Kirstin Gardner
Project Manager
Abergelli Power
49 York Place
Edinburgh
EH1 3JD

Our Ref: EN010069

Date: 20 April 2018

Annex 1: Comments on draft Development Consent Order (DCO)

2.4 Rights of Way Streets and Access Plan

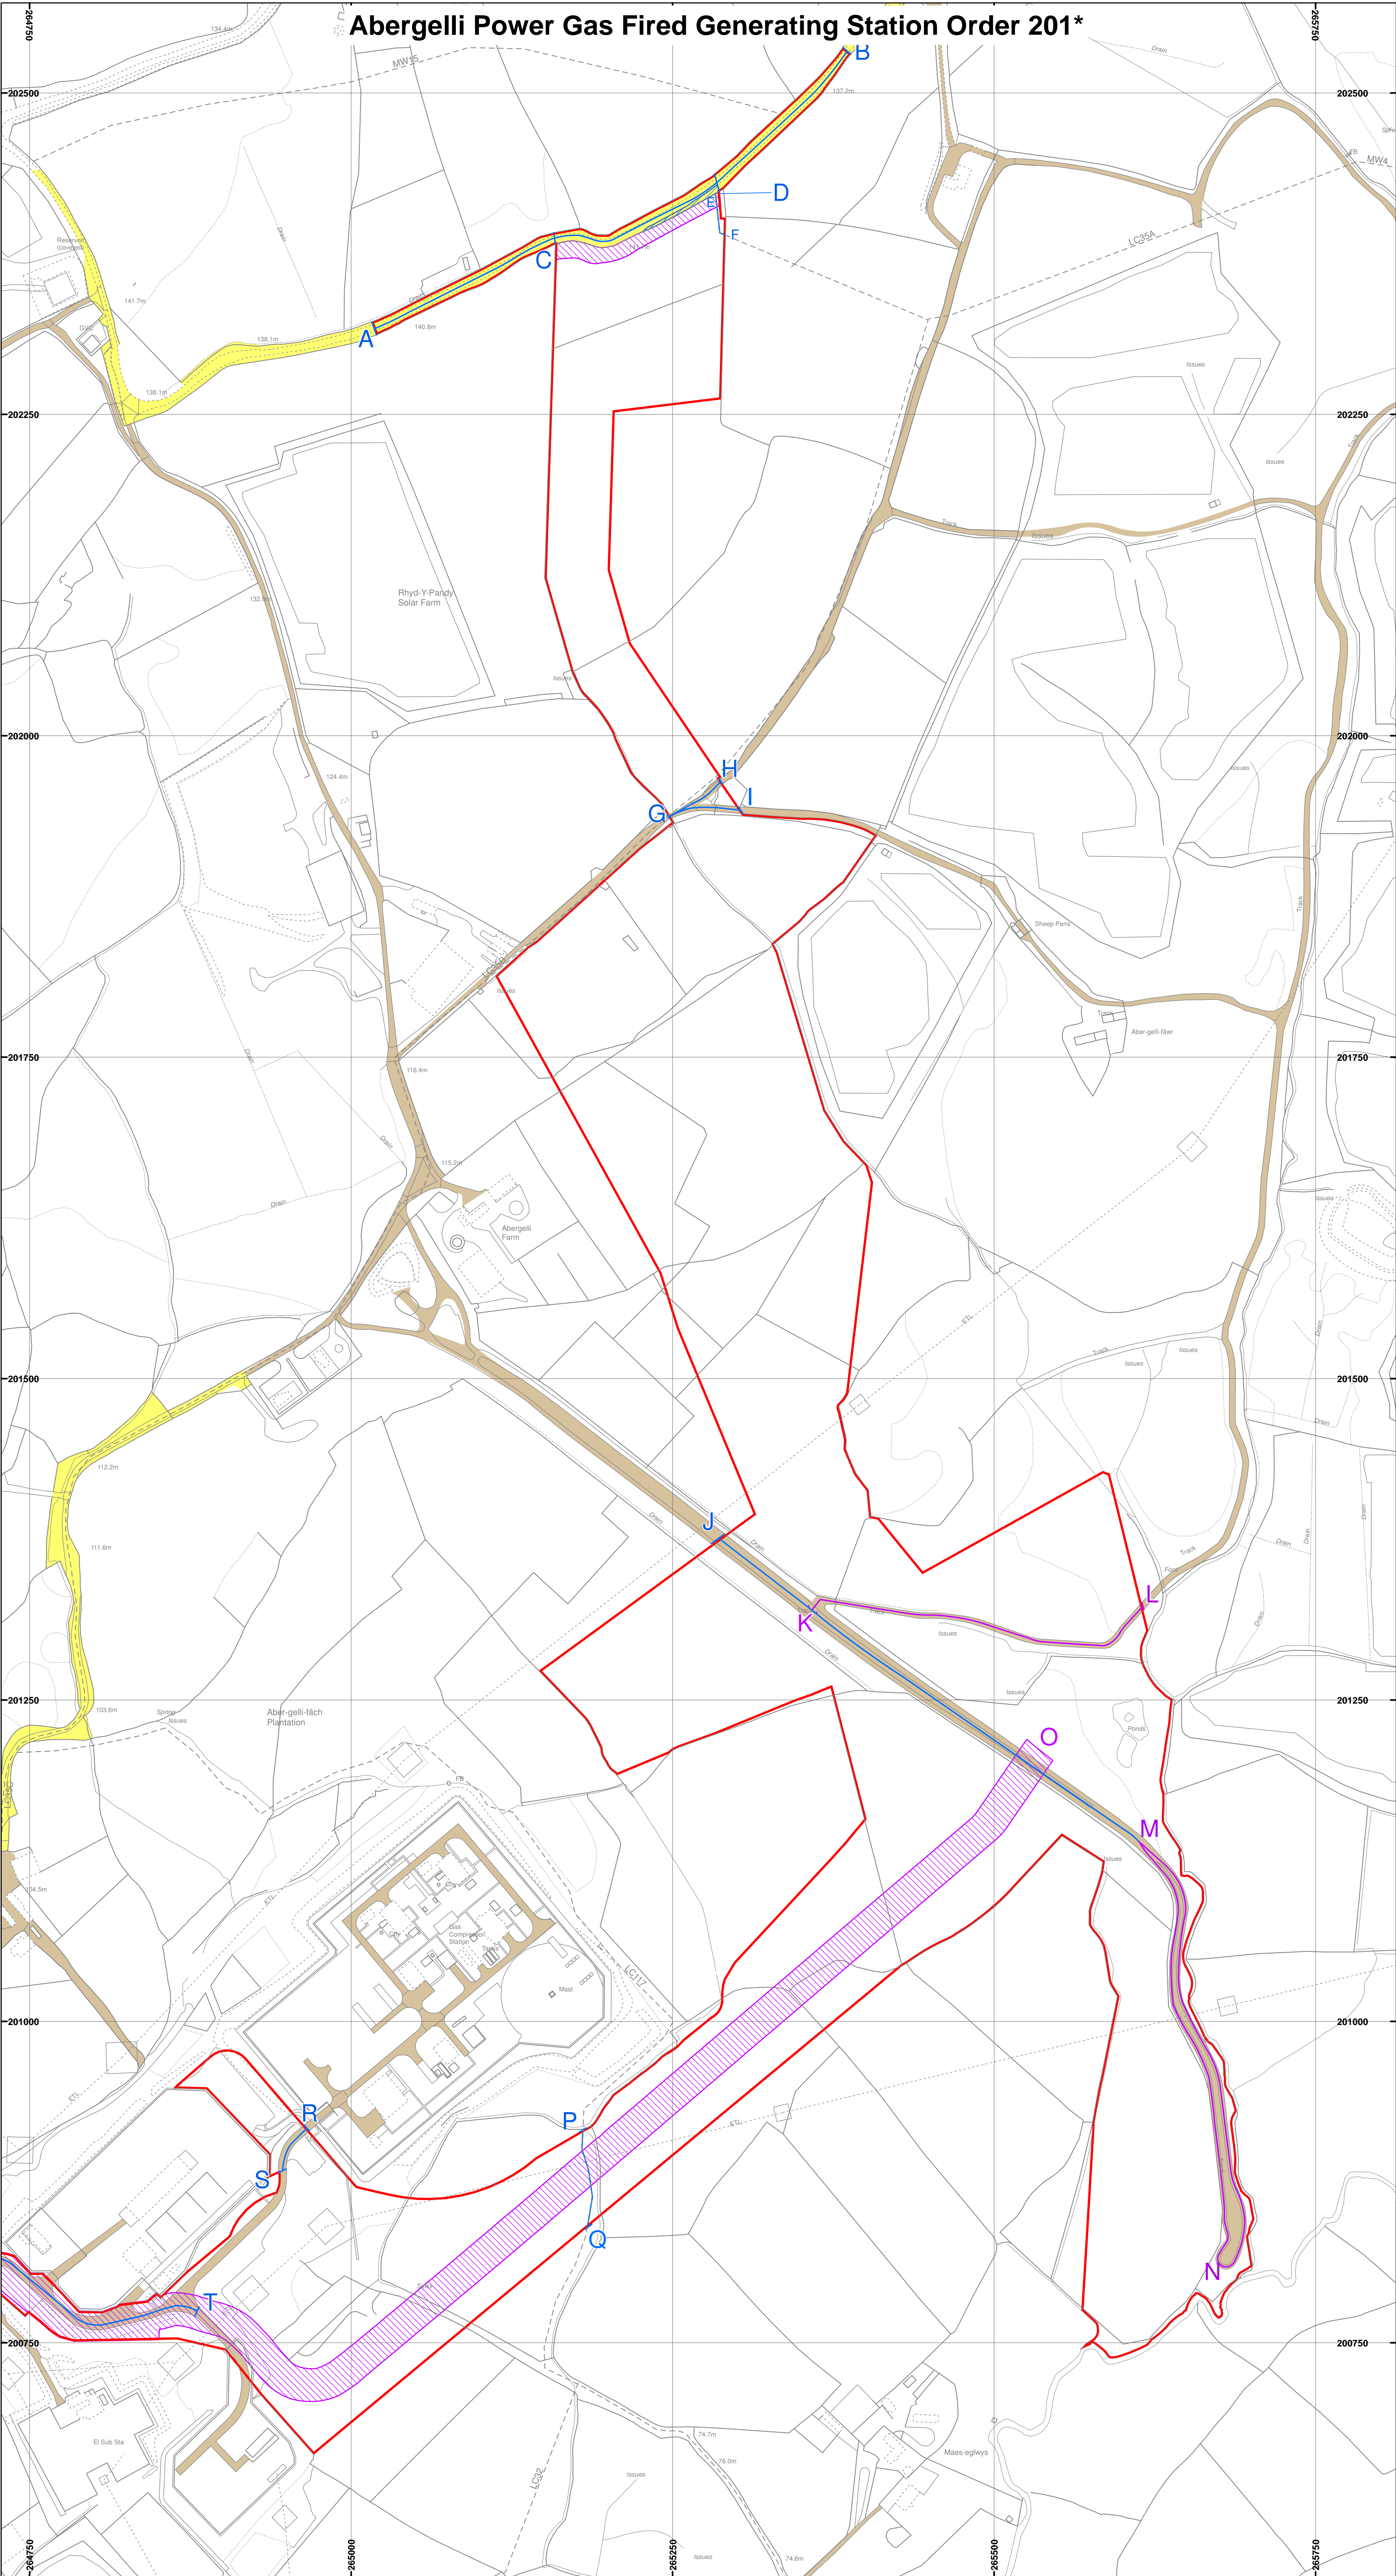
Point number	Paragraph number	Question/ Comment
1	General	<p>In reference to the following plans:</p> <ul style="list-style-type: none"> • Land Plans (Sheets 1 of 2 and 2 of 2), • Works Plan (Sheet 1 of 1), and • Rights of Way, Streets and Access Plan (Sheets 1 of 2 and 2 of 2). <p>All Plans show direction of North, are referenced and dated, and refer to APFP Regulations.</p>
2	General	<p>There is clear distinction between what is freehold land, new rights, and temporary land to be acquired for Compulsory Acquisition purposes.</p>
3	Works Plan (Doc Ref 2.3)	<p>It is difficult to understand from this plan where the different works would be located (specifically in the diamond-shaped area where the power station etc would be located). It is understood that this information is difficult to clearly display on one plan.</p> <p>Therefore could other plans be provided which illustrate the individual works in addition to this plan?</p>
